Application No: CM/38/21/PL
Site Address: The Arundel Gardener and Maidenhead Aquatics Crookthorn Lane Climping BN17 5SN
Description of works: Retention of timber cladding to side (west) & rear (south) of main building, Laying new shingle to existing made ground, lychgate to west of main building, timber cladding to generator housing & laying block paving and concrete slabs/replacement concrete slabs. This site may affect a listed building & is in CIL Zone 5 (Zero Rated) as other development.

Thank you for your internet representation made on 18th August 2021 which has been recorded as an objection with the comments as follows:

*As-Existing Site Plan
with Proposals*

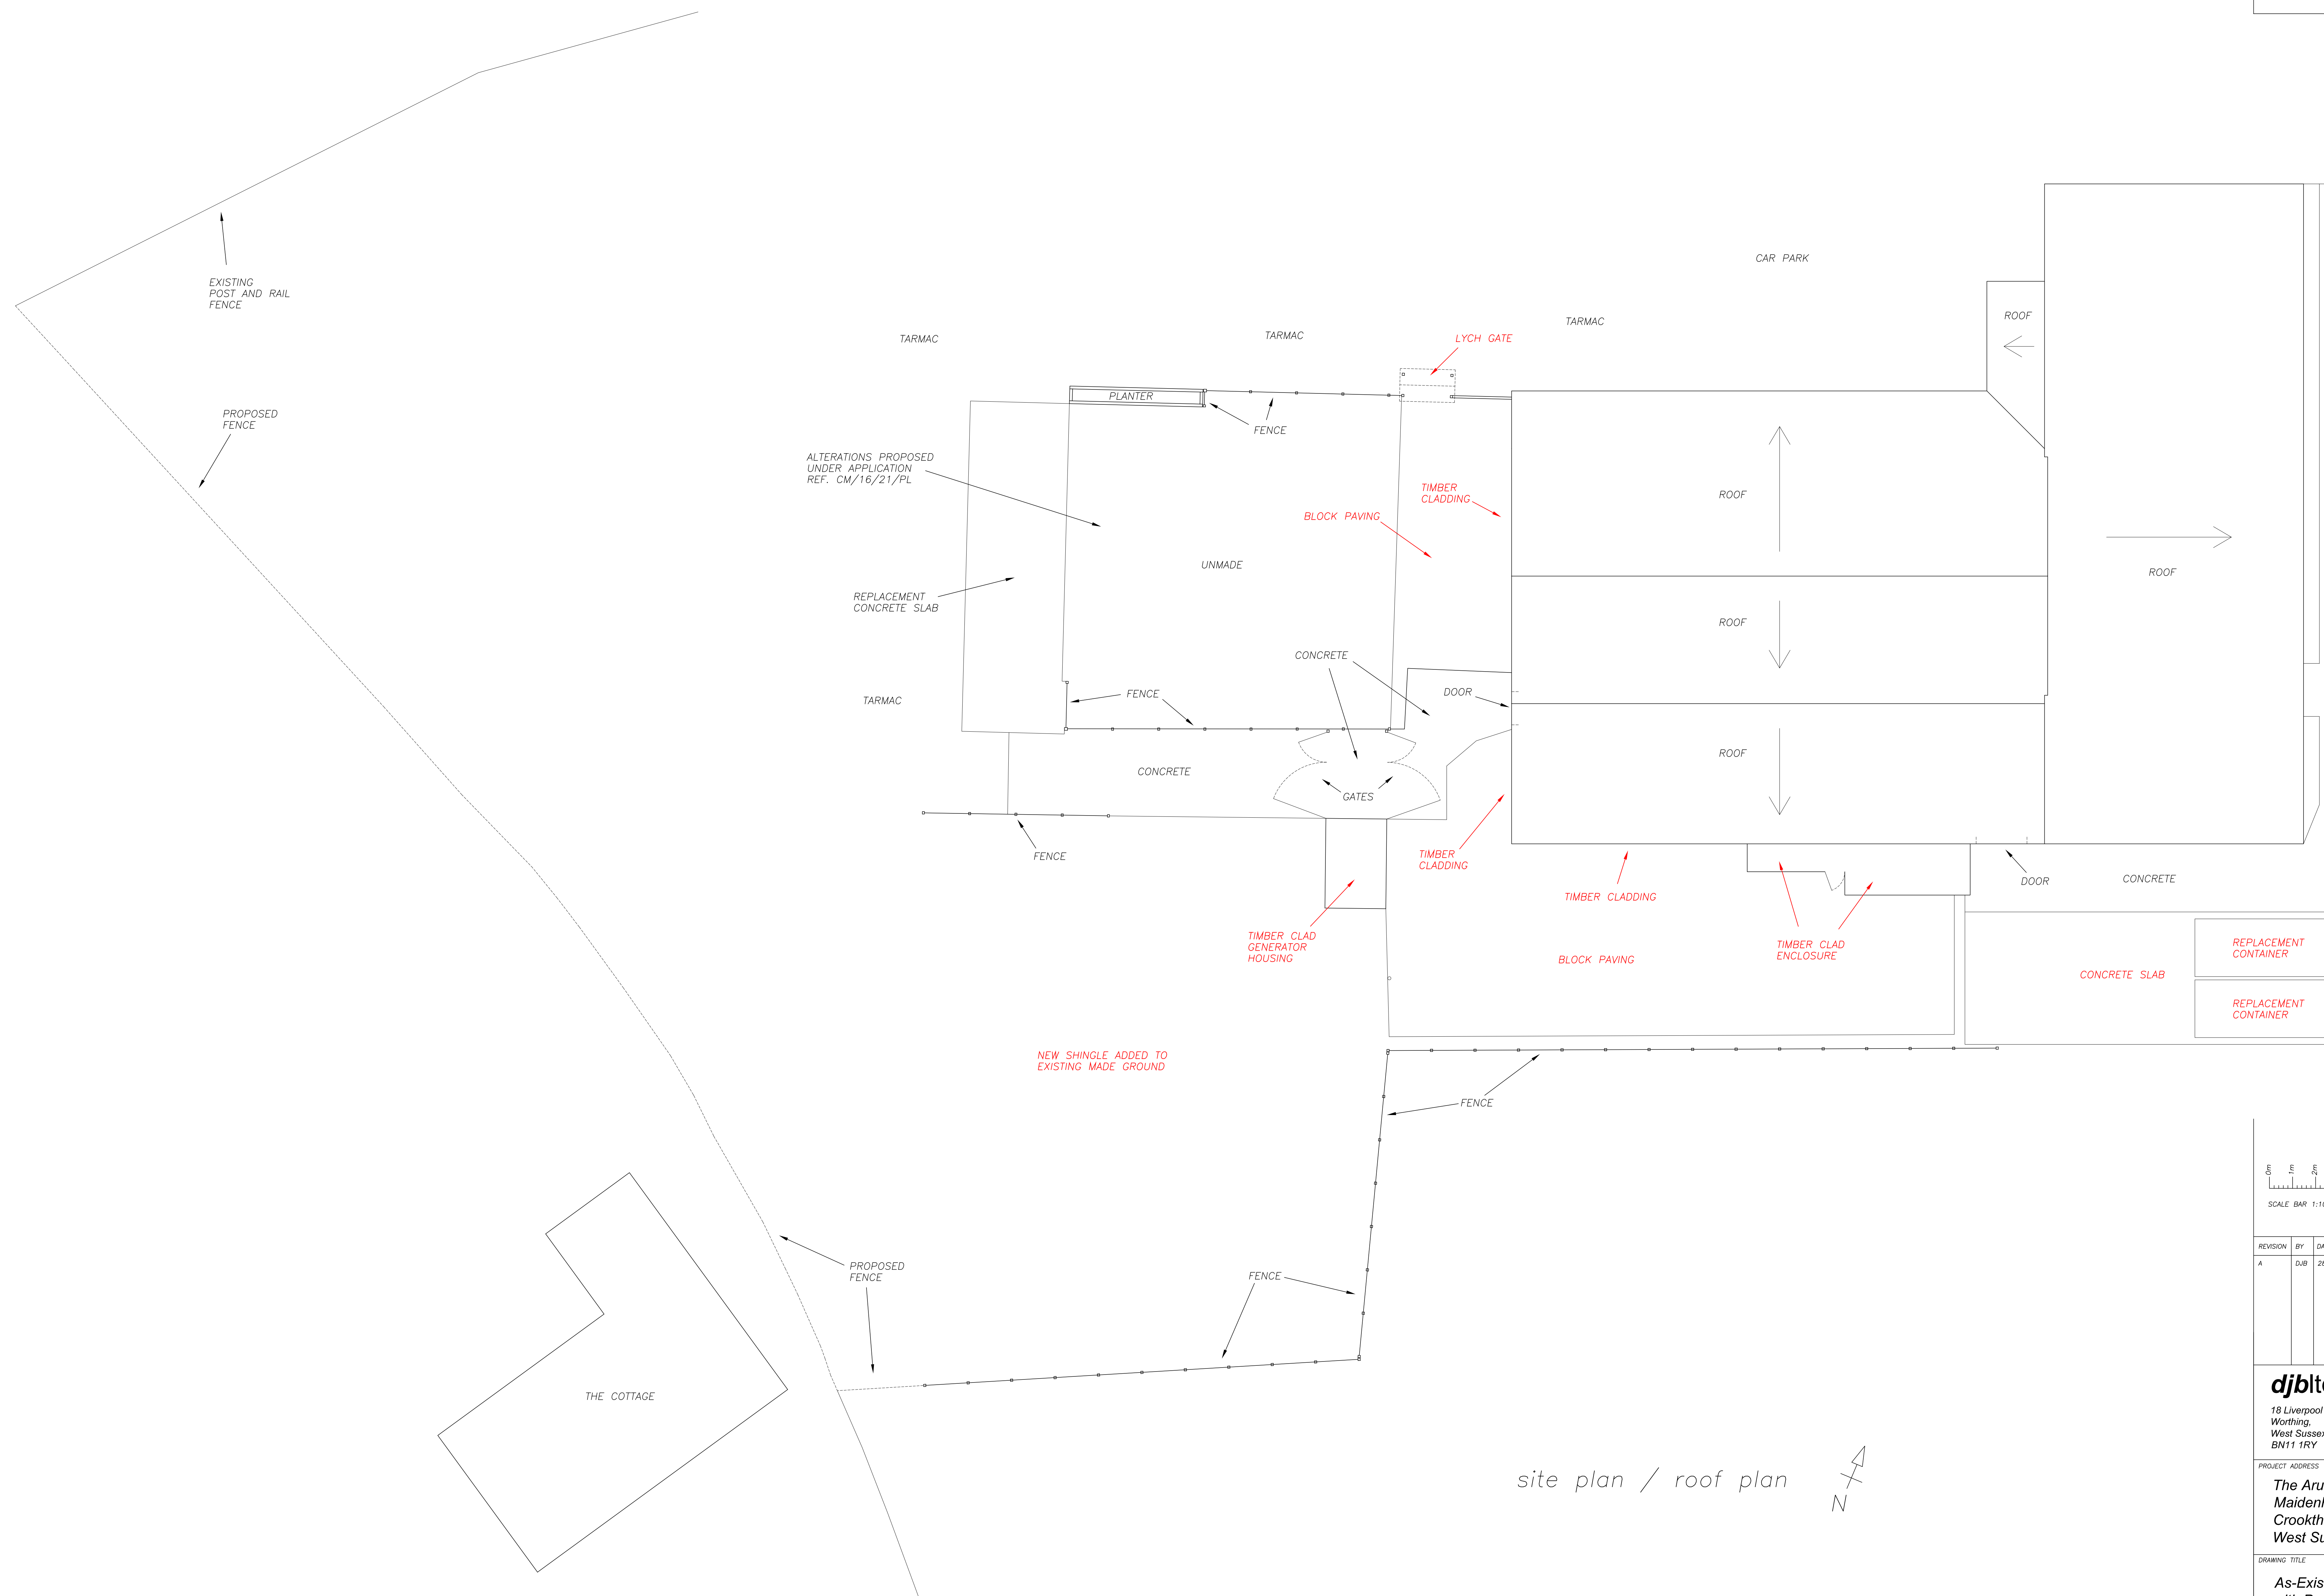
4. Generator housing (south side)- these units should not be housed so close to a dwelling, a Listed Building. There is no indication of running hours Noise issue) of the generators or their purpose. (Pls note there are also generators on the east side of the building).Query 2 lots of generators required?.

6. The ugliness of the rear of this garden centre will affect a Listed Building. Generators housing, shingle instead of grass fields, bright yellow trolleys in full view of the property, Climping Street, and the main A259

west elevation

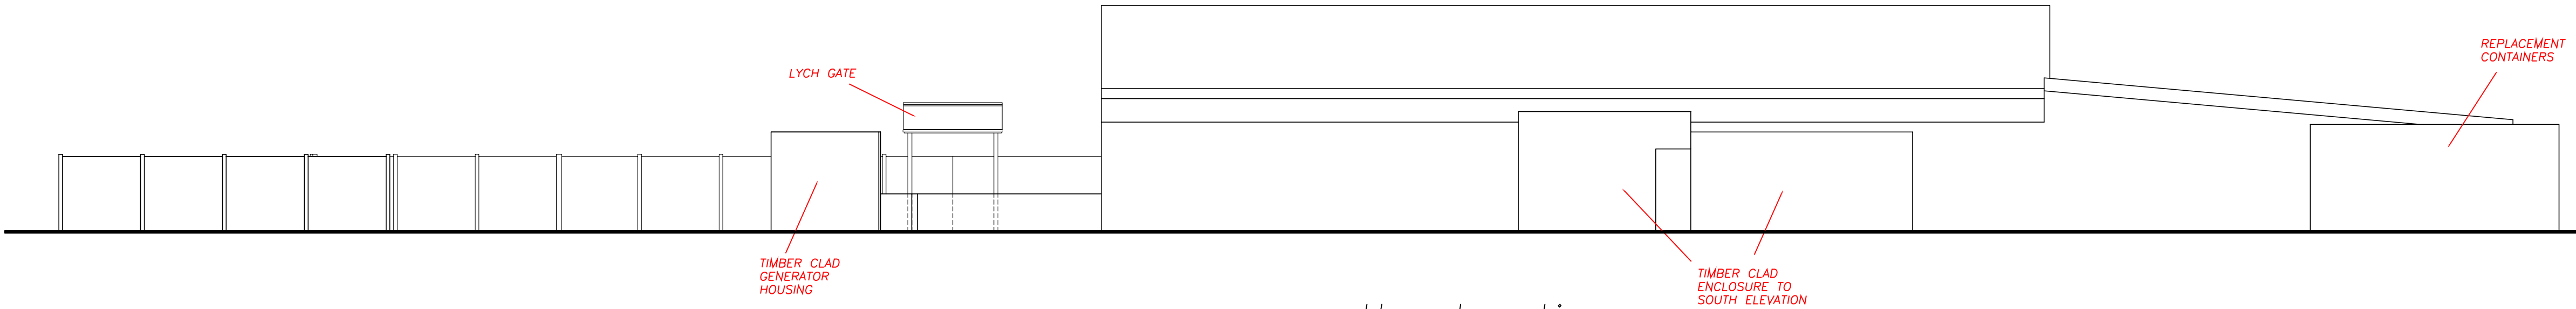
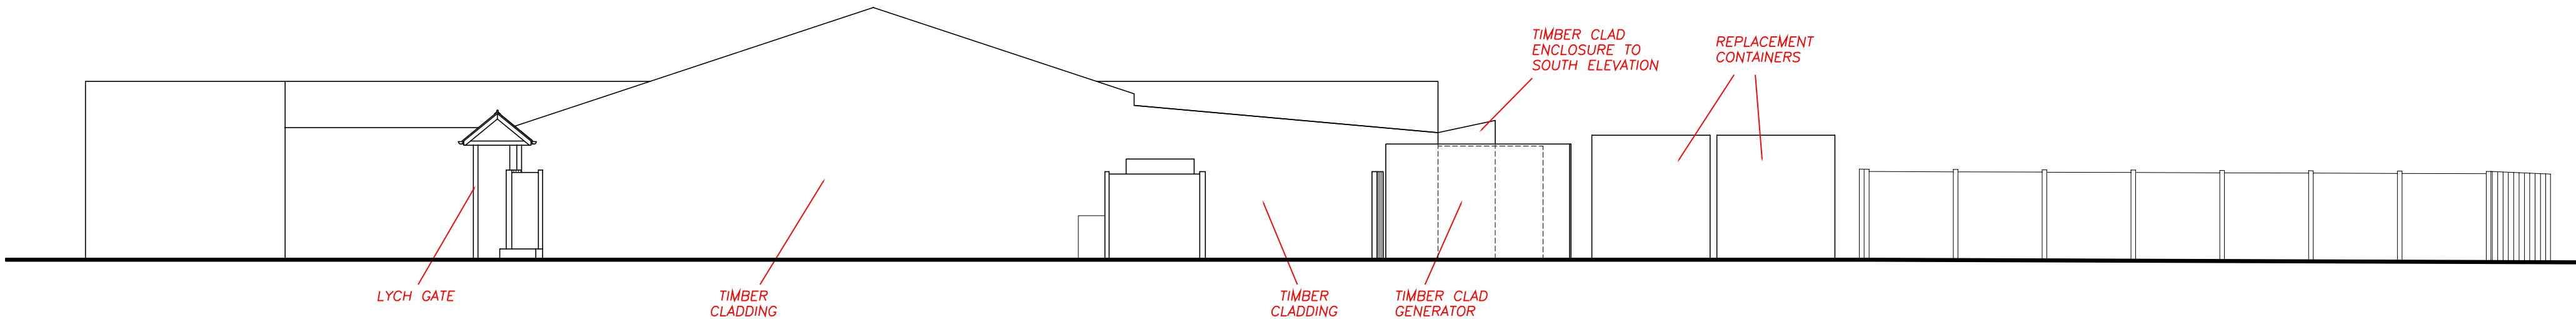
5. Timber cladding on west side will be near the Drive Through Cafe with its inherent Fire Risks. Fire Officer has already stated that the nearest Fire Hydrant is further away than it should be for commercial premises. This needs to be rectified before this permission is granted.
